DATE	14/03/2022	JOB	2808	PAGES	1 of 2
PROJECT	SSD-10371 - Trinity Grammar School The Renewal Project SSD				
TO	Peter Brogan				
COMPANY	Bloompark Pact				
FROM	PMDL				
REFERENCE	Architectural Response to Submission for Modification

### 2808 DA102 Site Demolition Plan LO + Above B

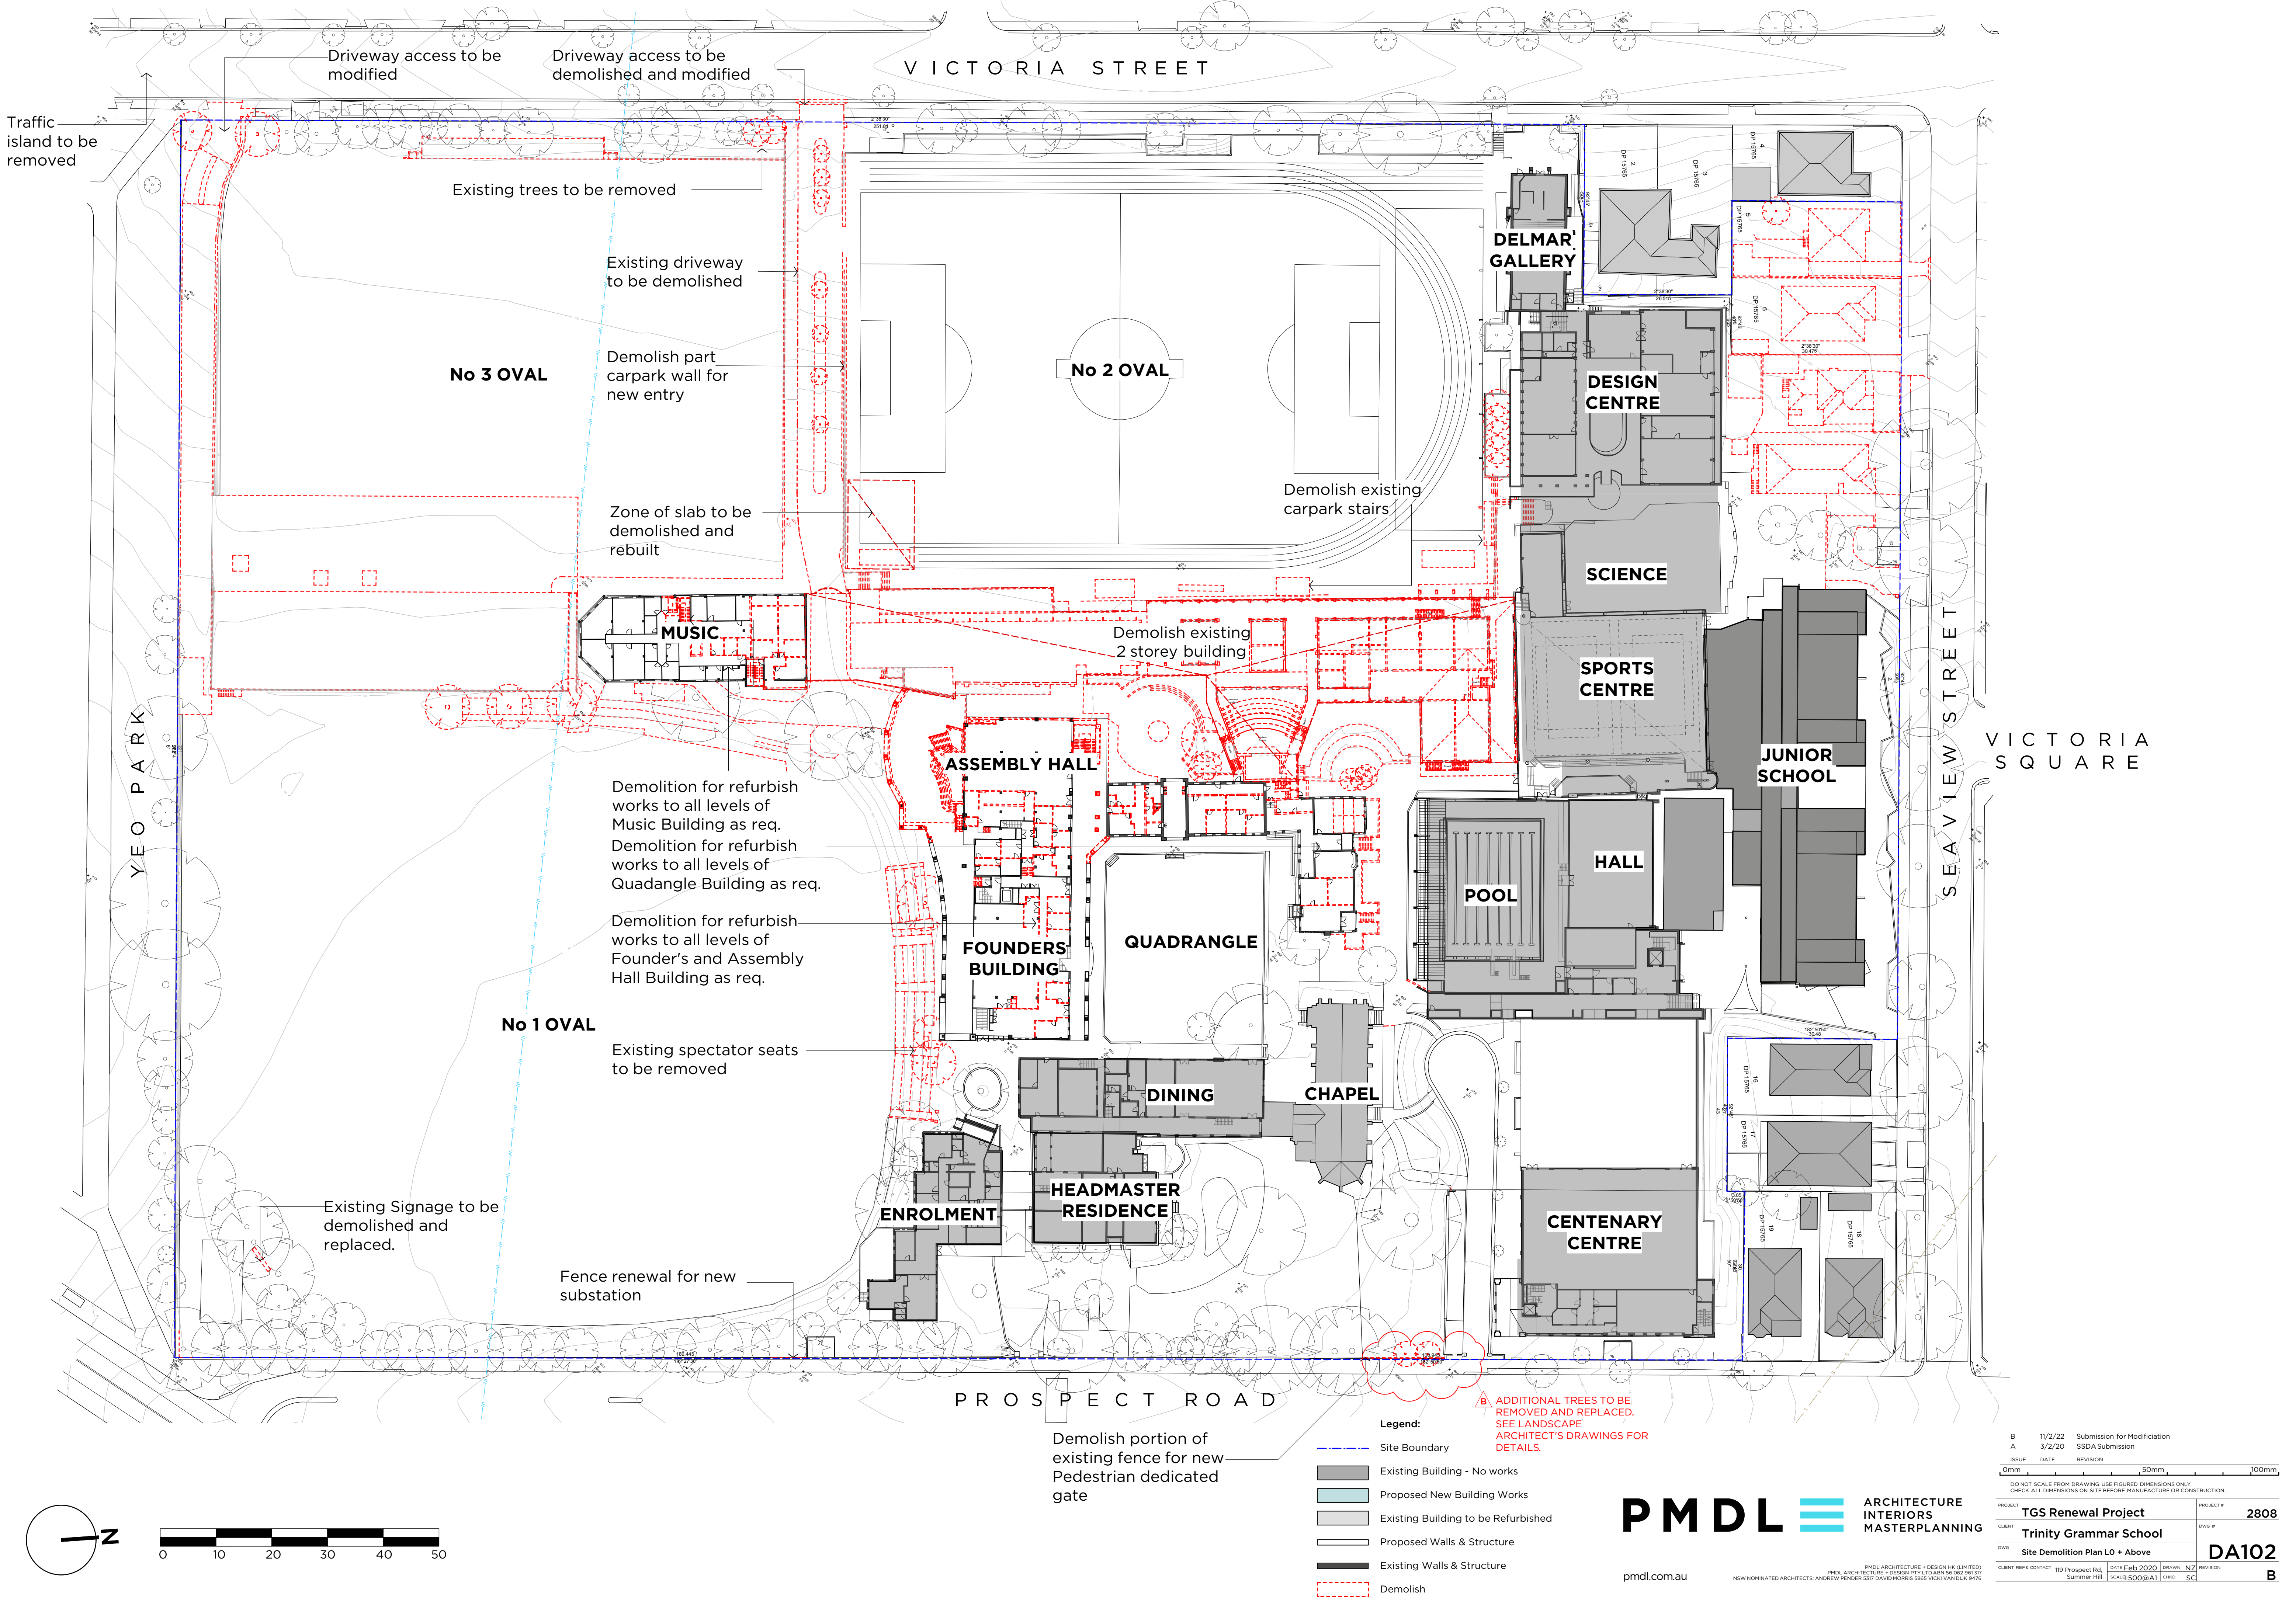
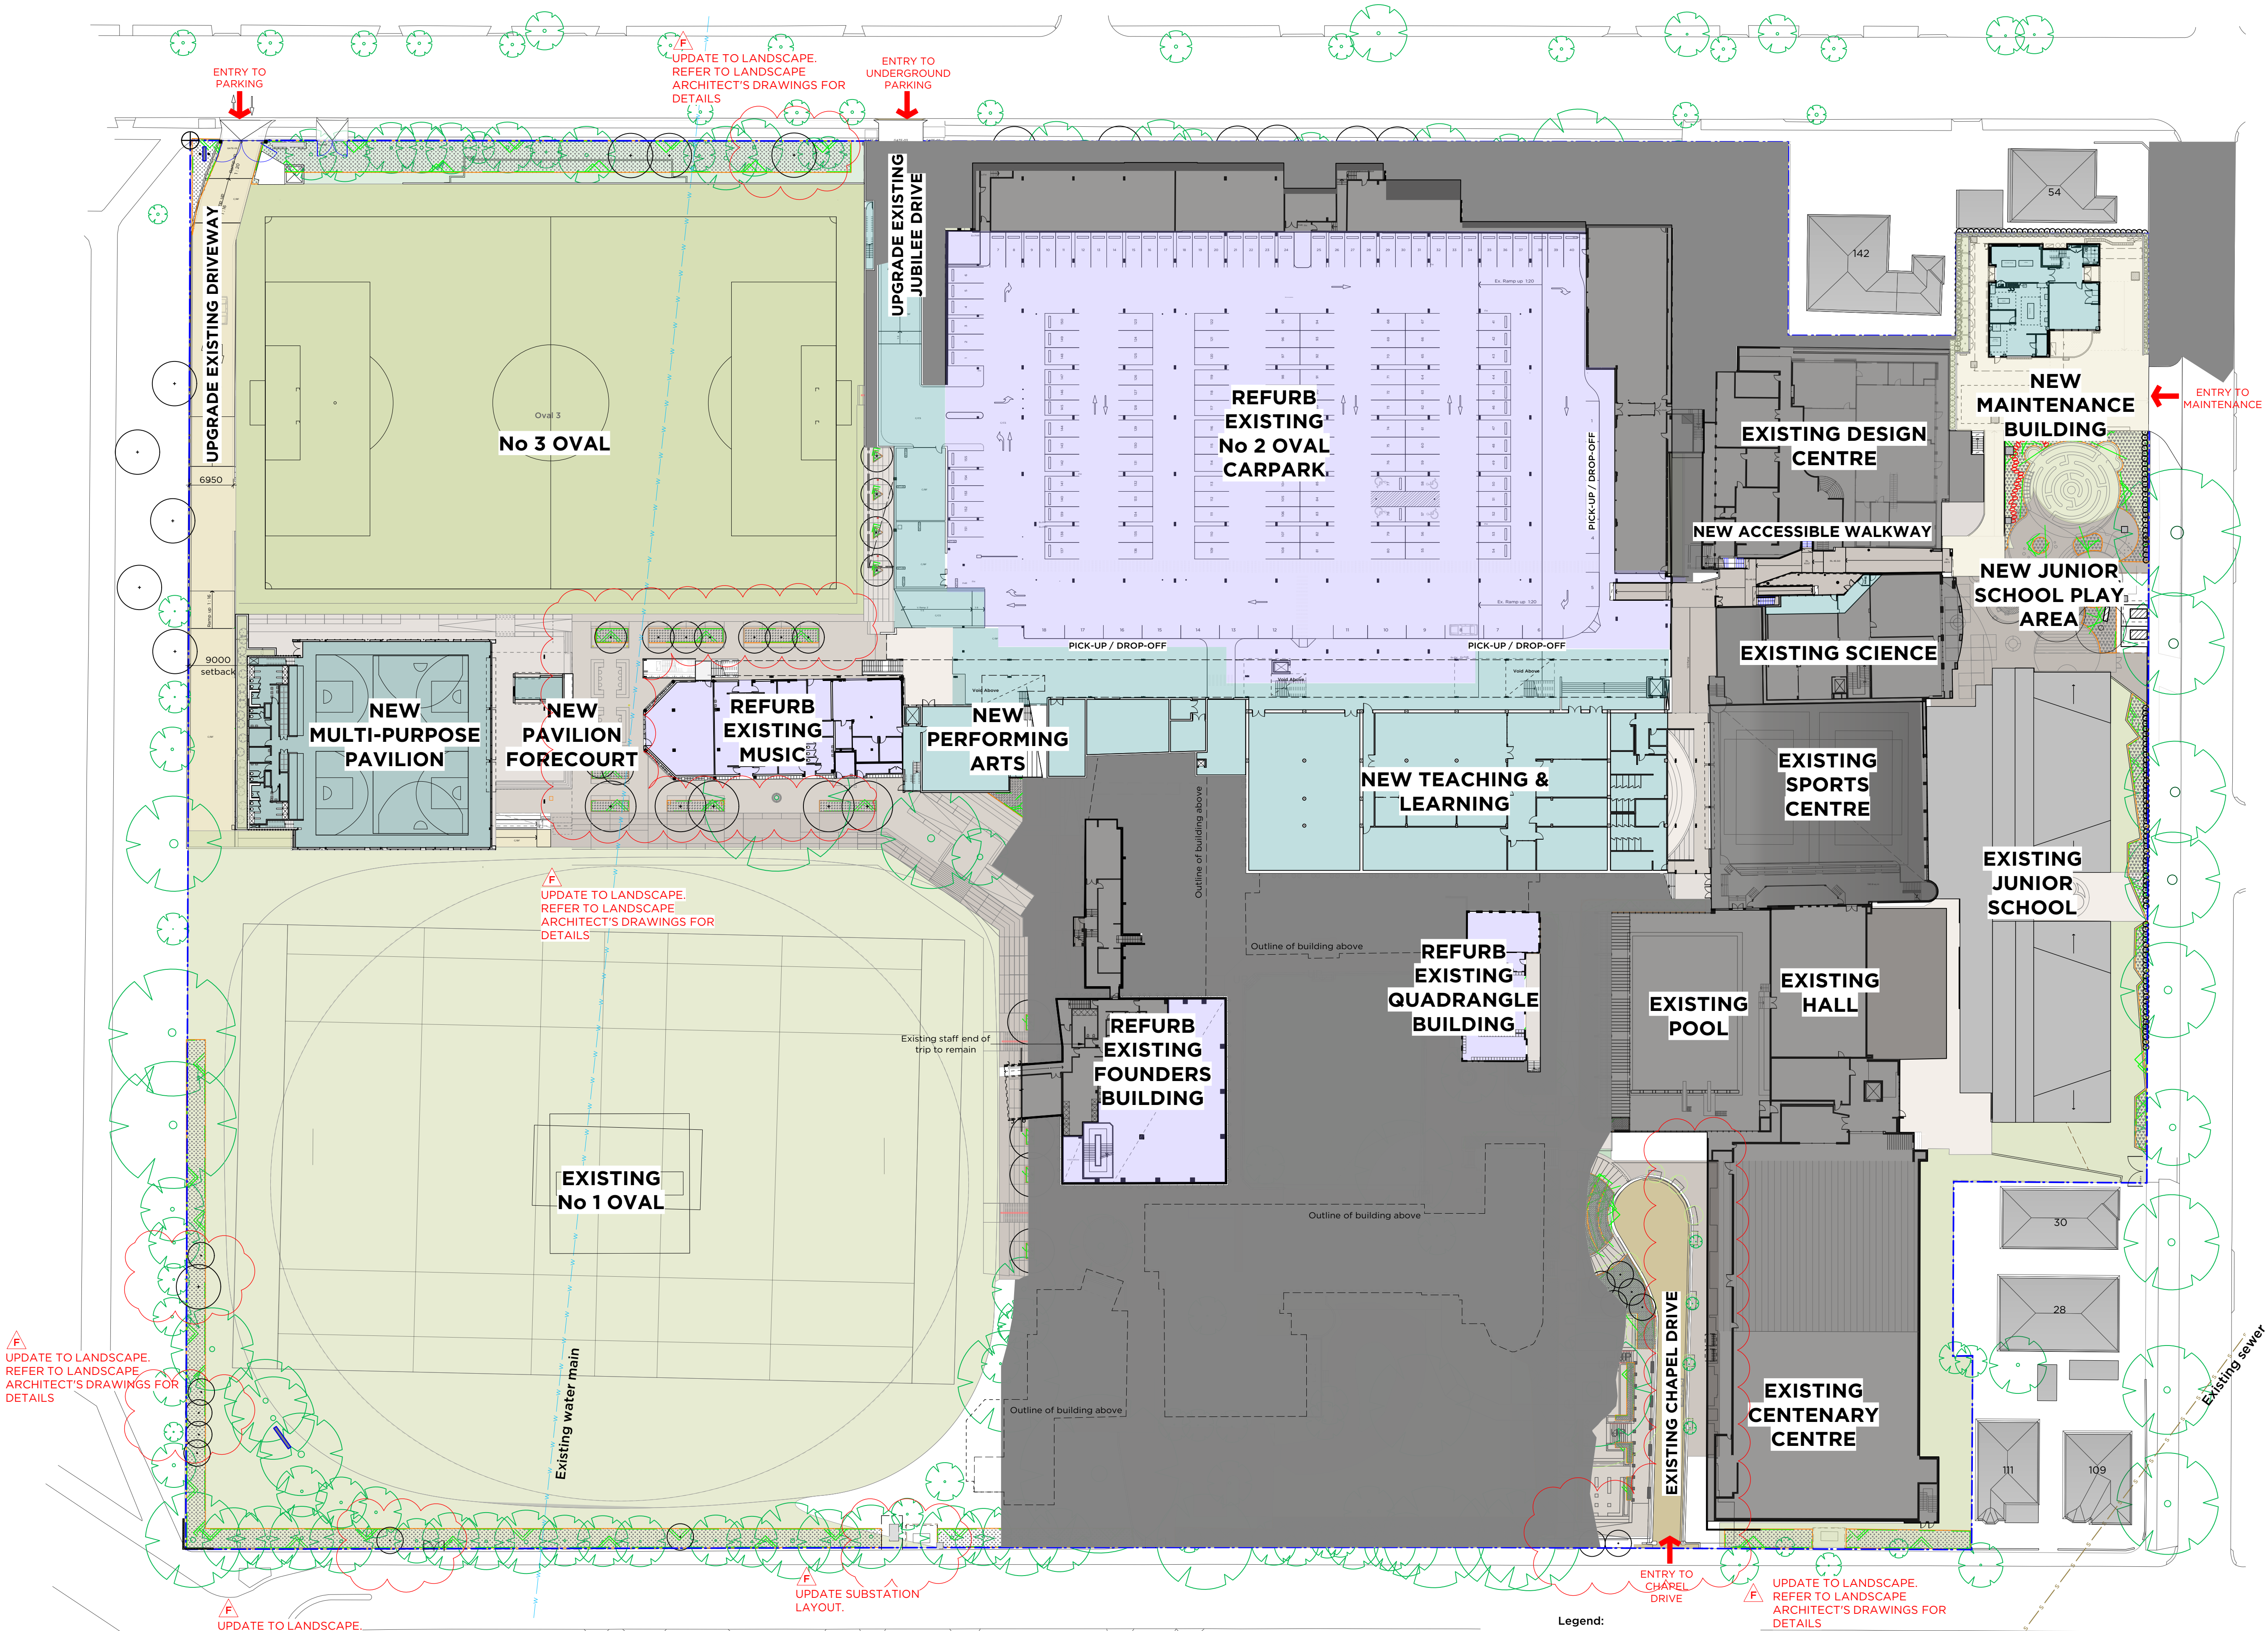
- Landscape design changes following design development and project coordination.

01 PLAN
DA131 Level B1 Proposed
Scale 1:200

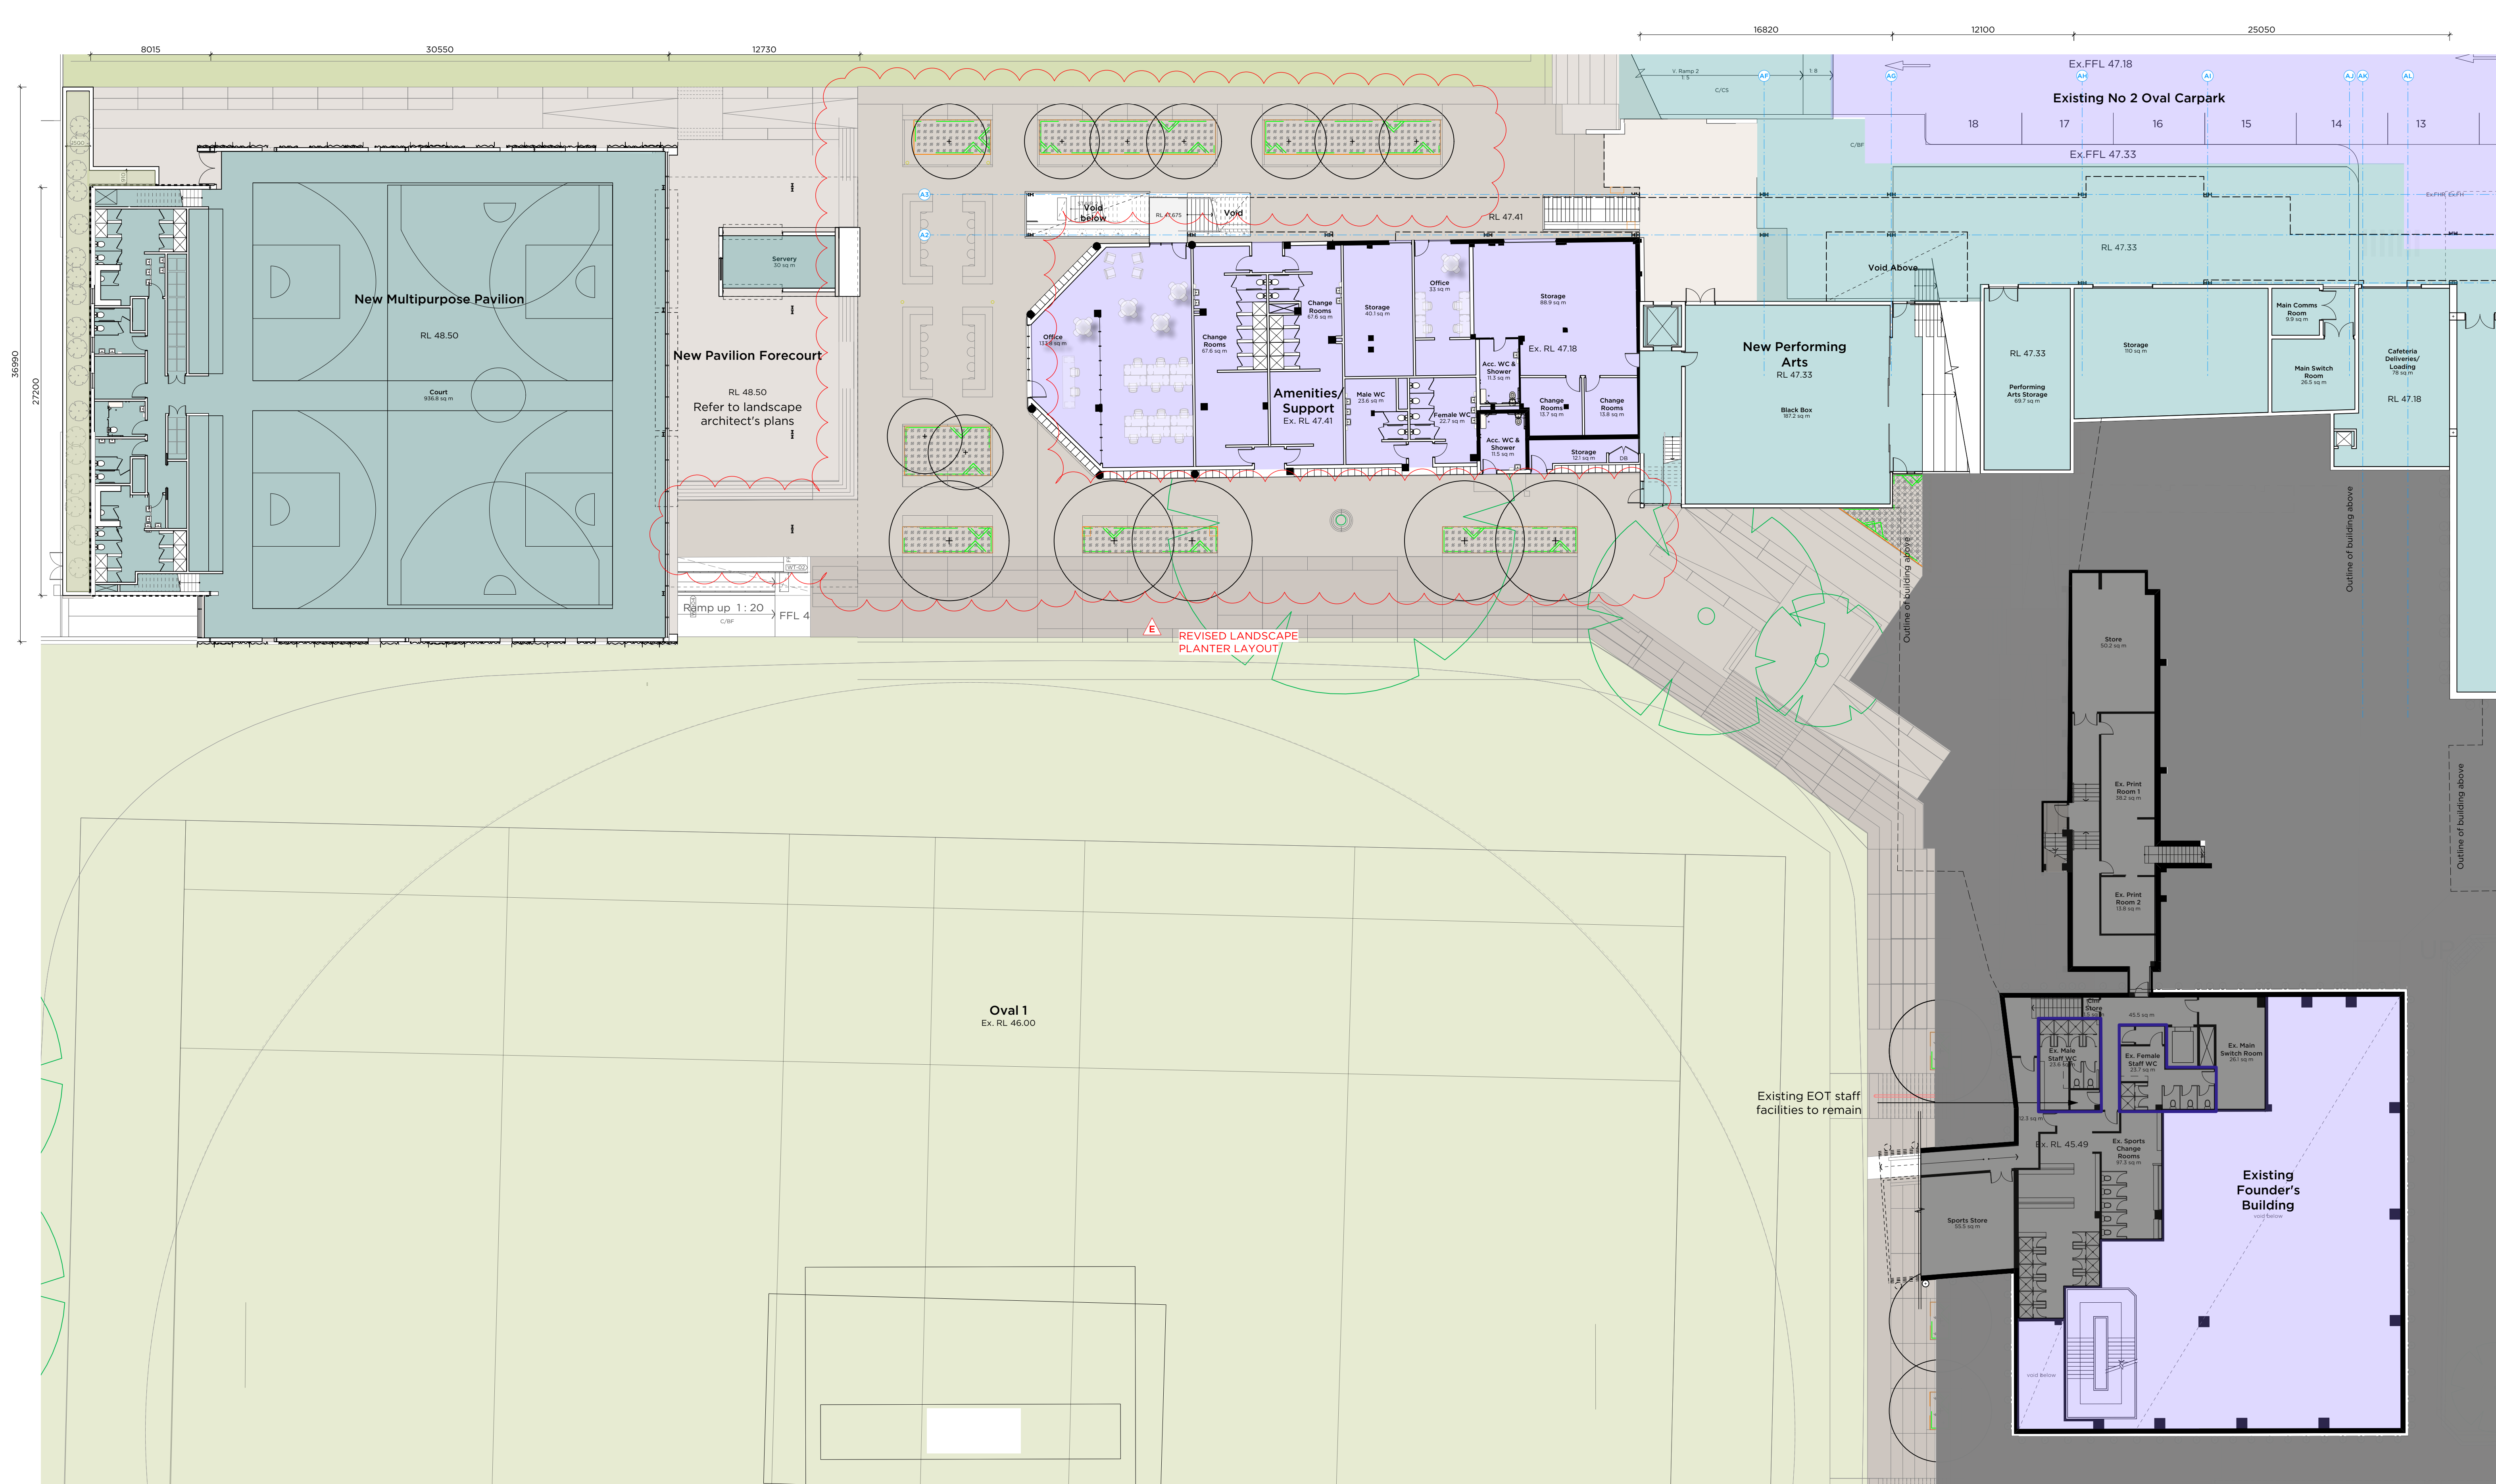
- Landscape Planter design changes following design development and project coordination.
